Ref: Planning Application: AW/129/18/HH

**OBJECTION TO PLANNING PERMISSION – 20 ALDWICK GARDENS
APPLICATION: AW/129/18/HH**

Proposed South Elevation

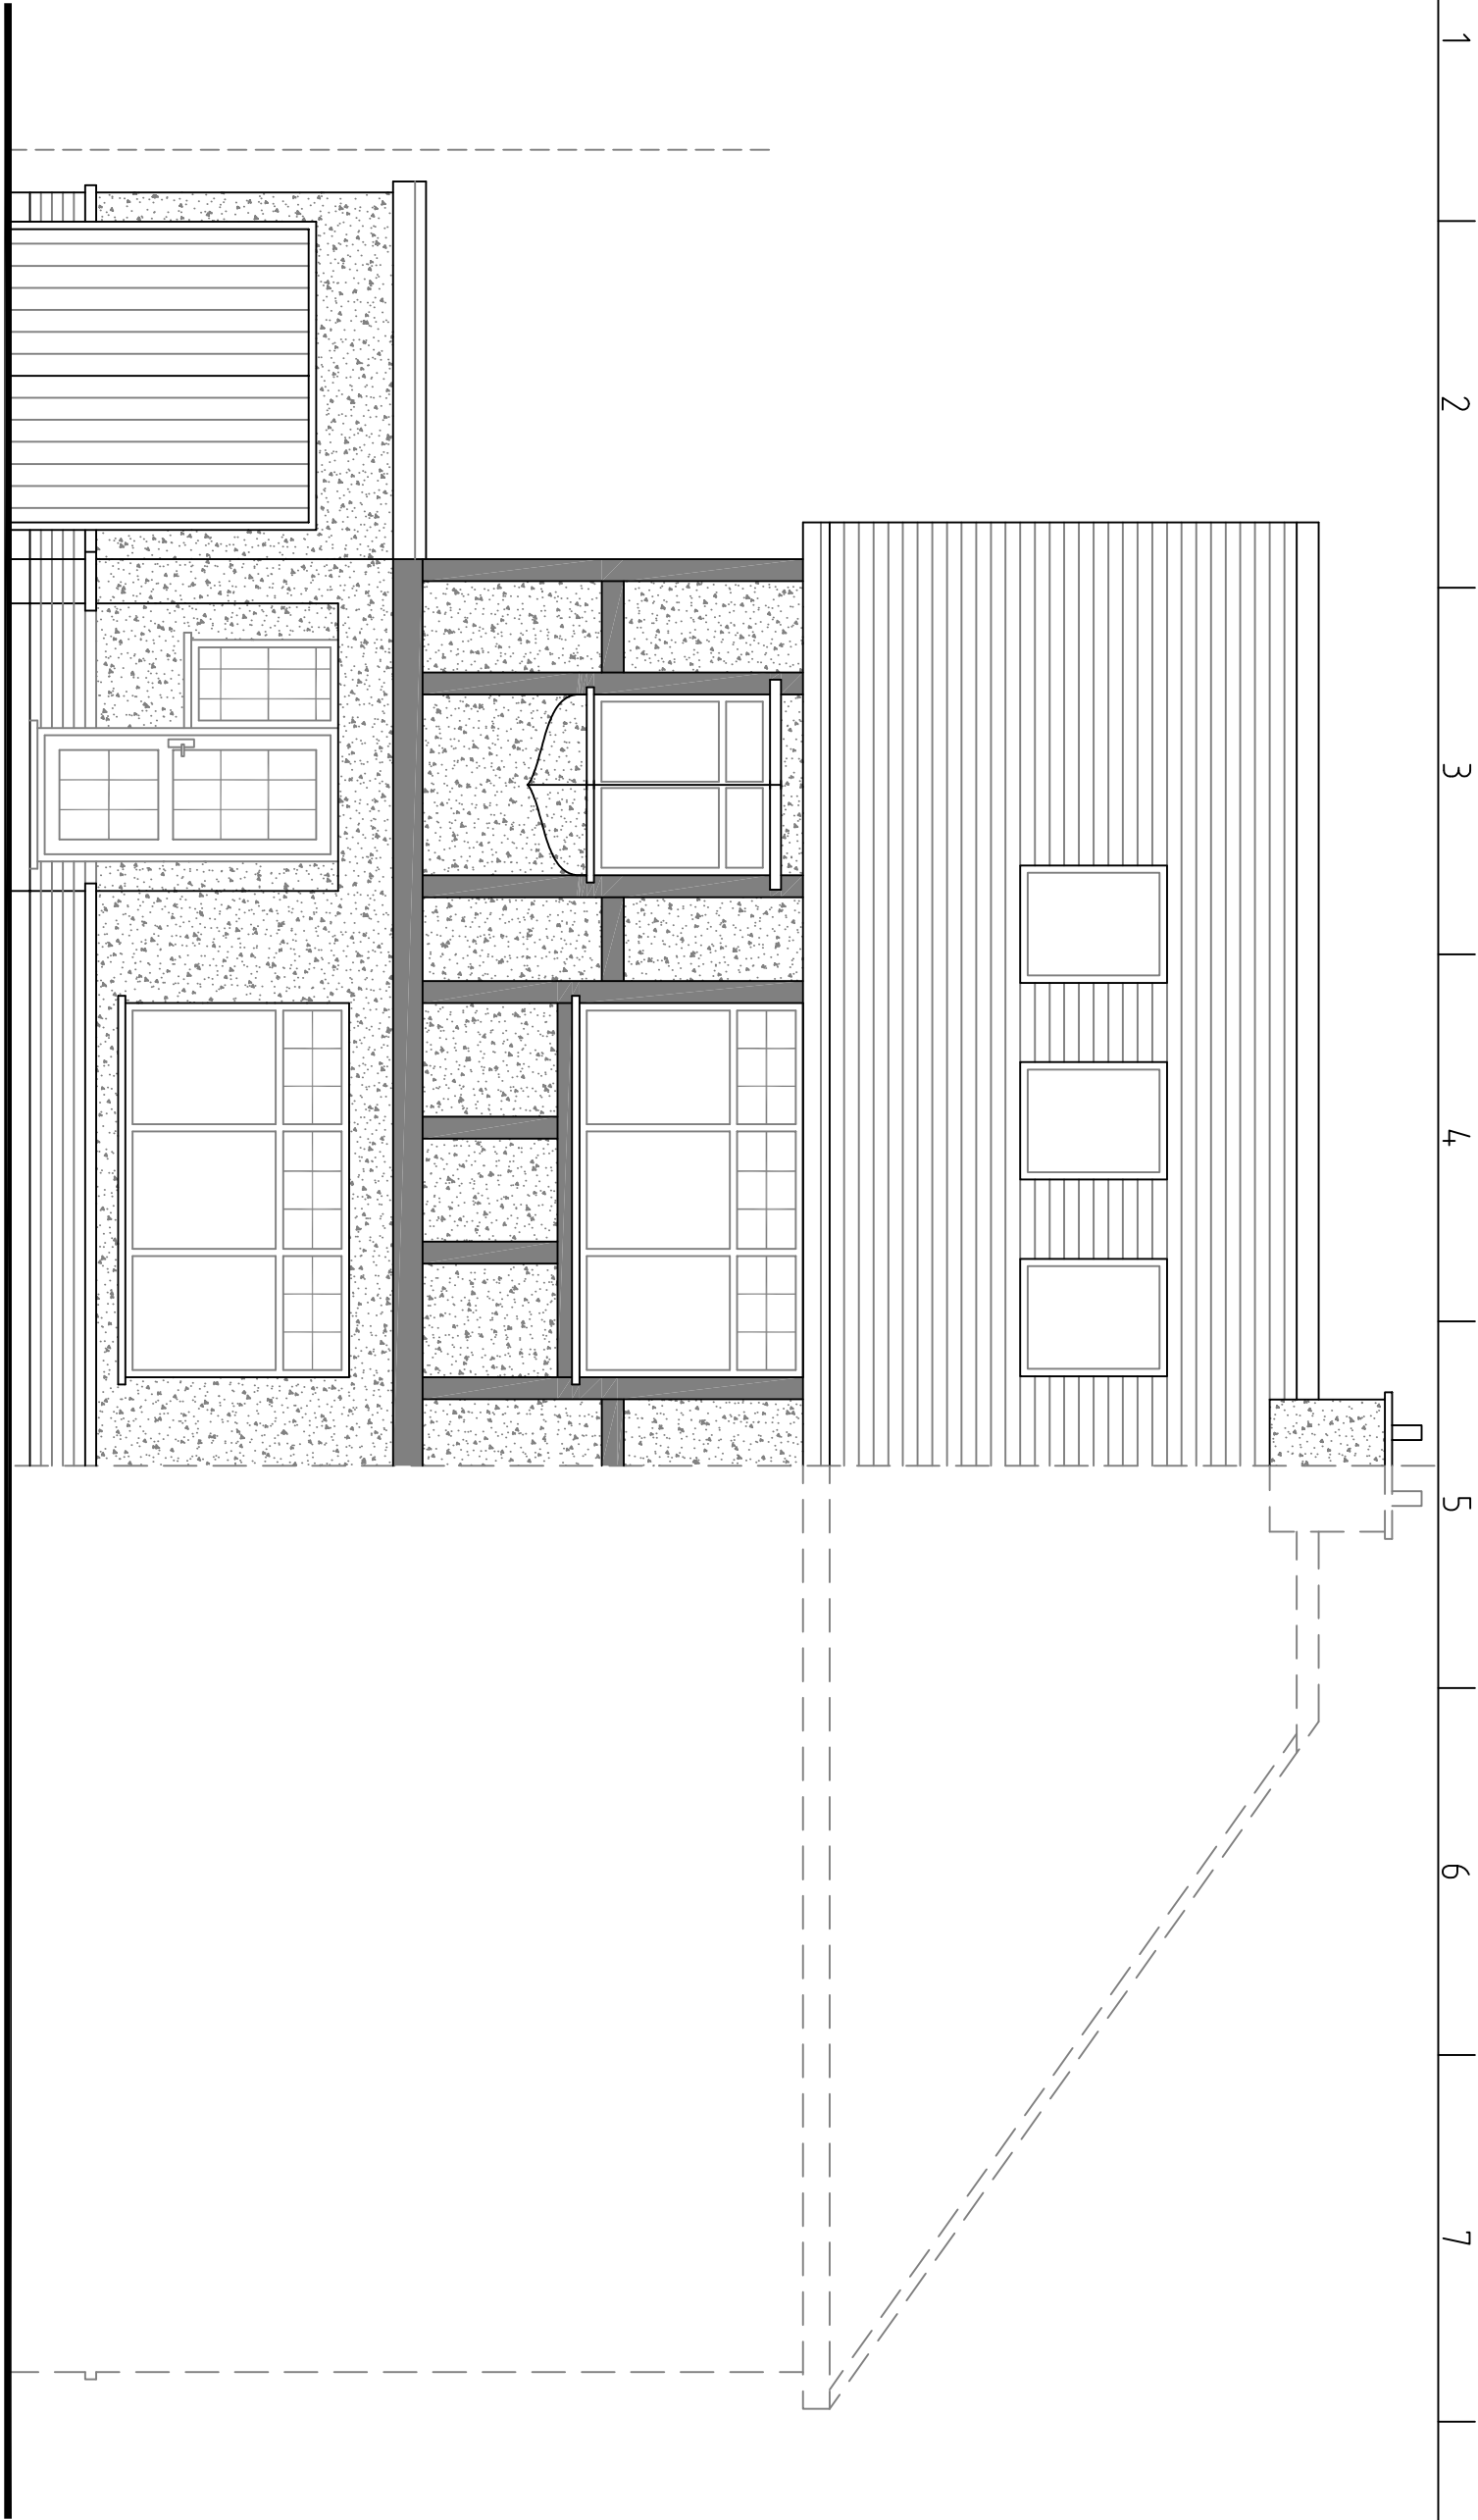
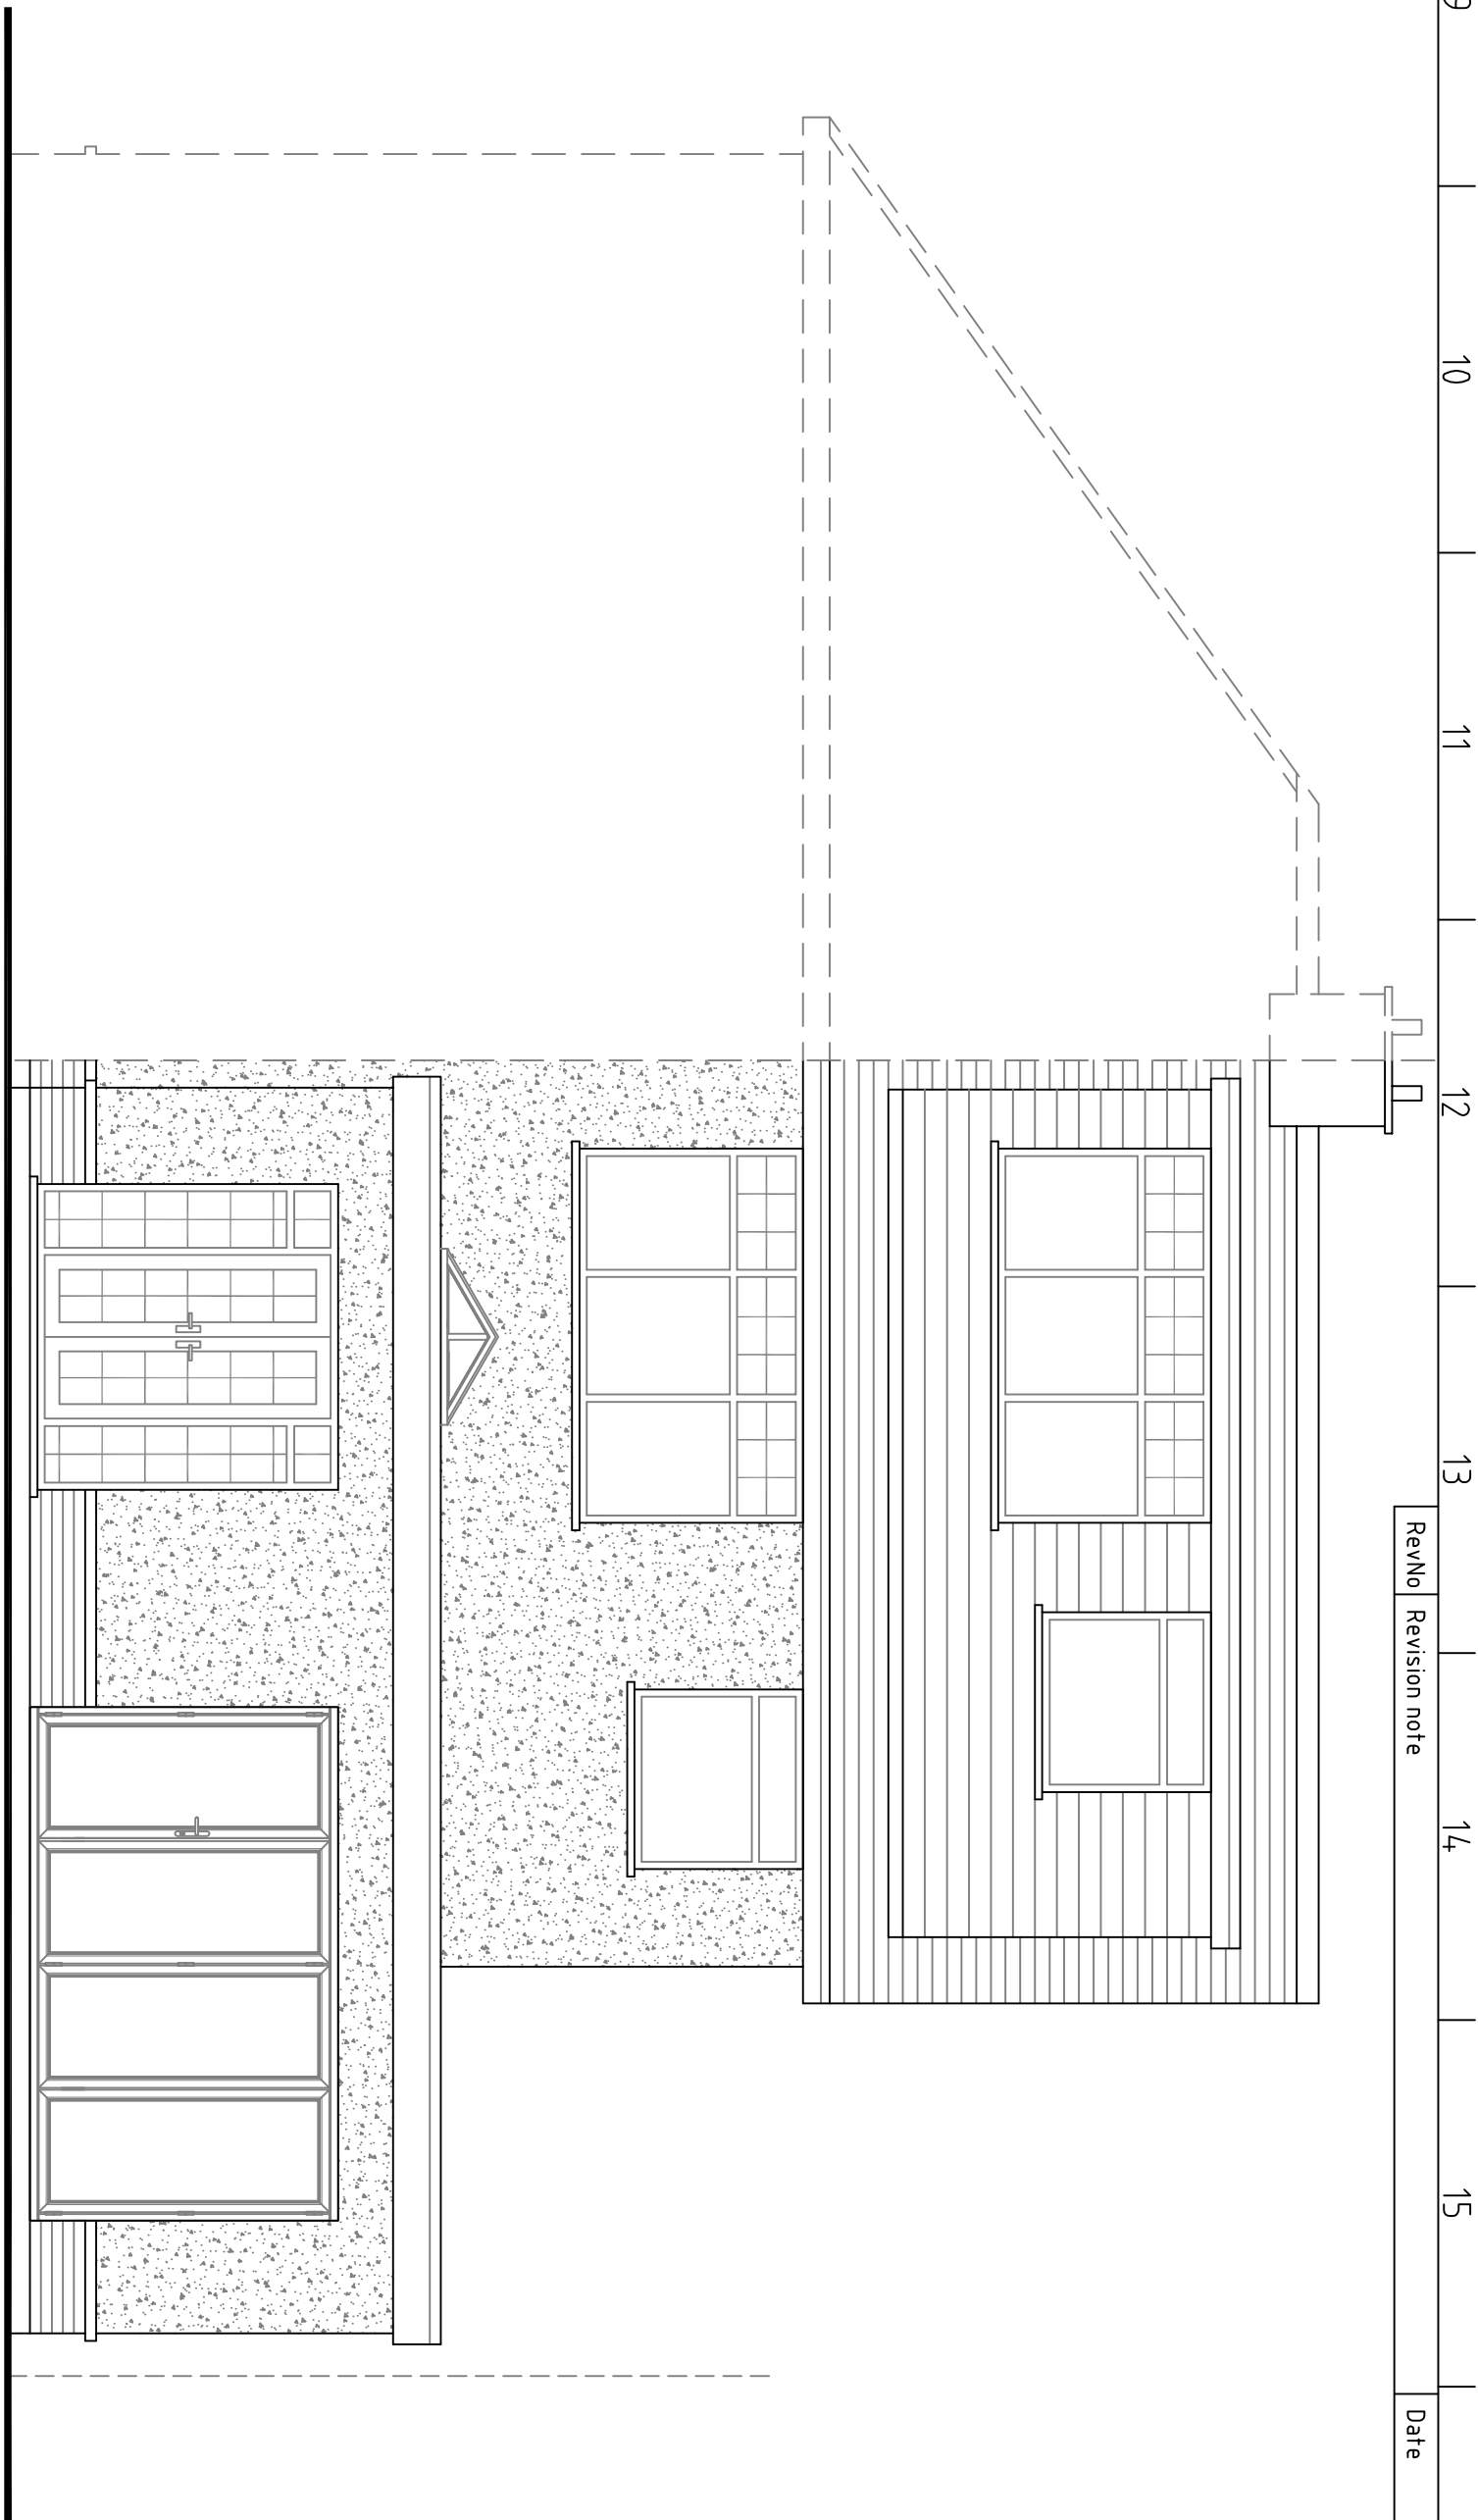
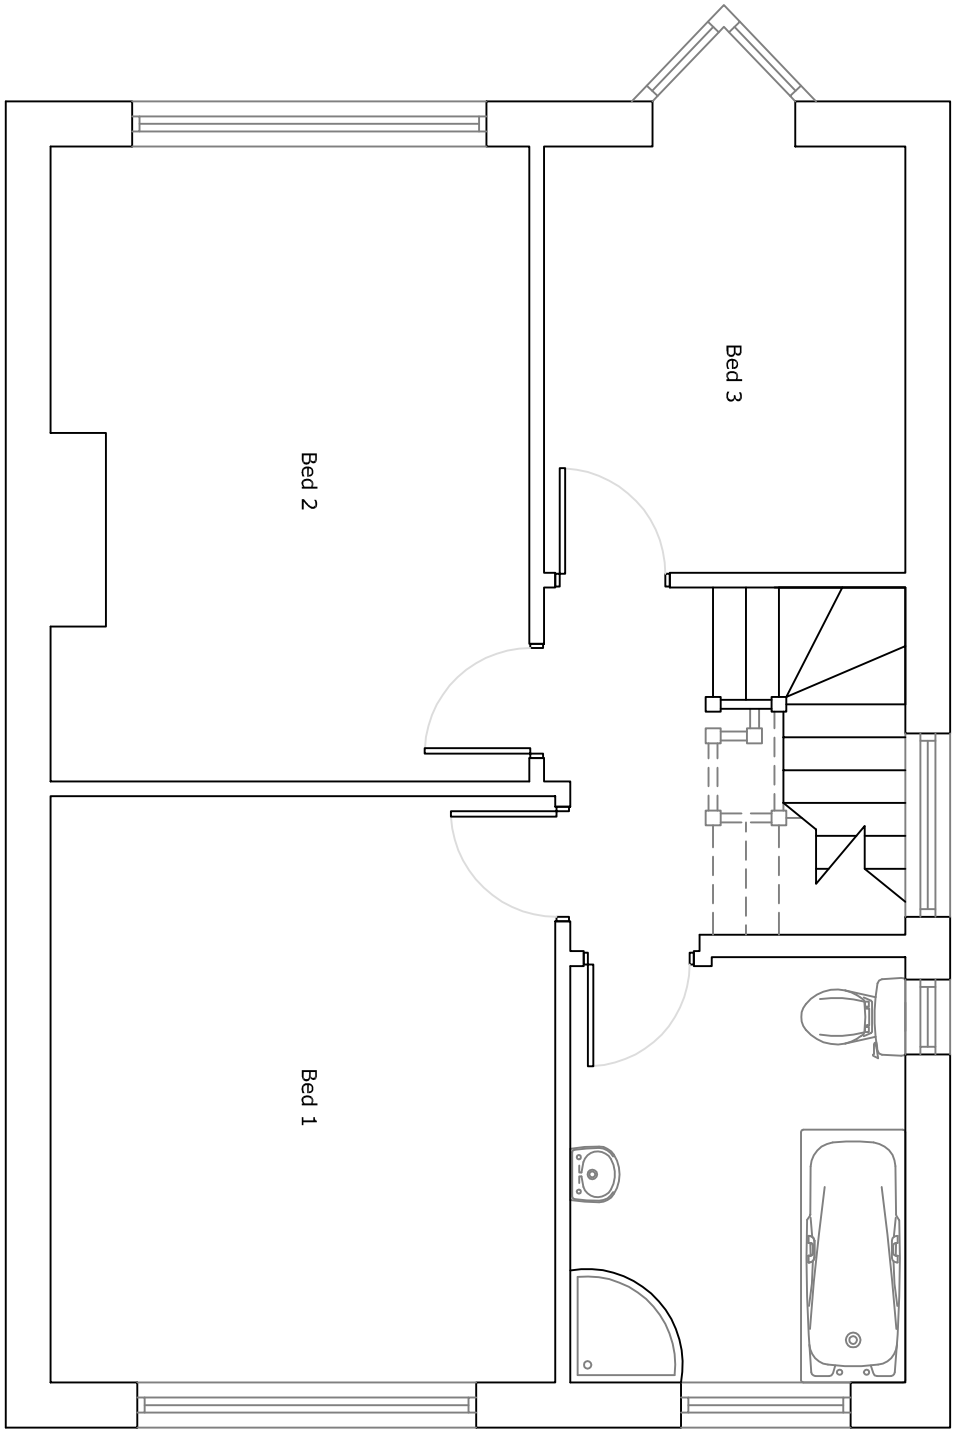
The house is at present a fairly attractive semi-detached with a standard pitched tiled roof. The proposed loft conversion will effectively make it a 3-story building as the plans show a squared off box type roof structure which looks as if it overhangs the side of the building. This proposed new roof in our opinion is completely out of character to the type of roof that exists on properties in this road, namely pitched.

As owners of the bungalow next door (no 22), the new construction will tower over our home and garden, invading our privacy and also restricting sunlight at times of the year.
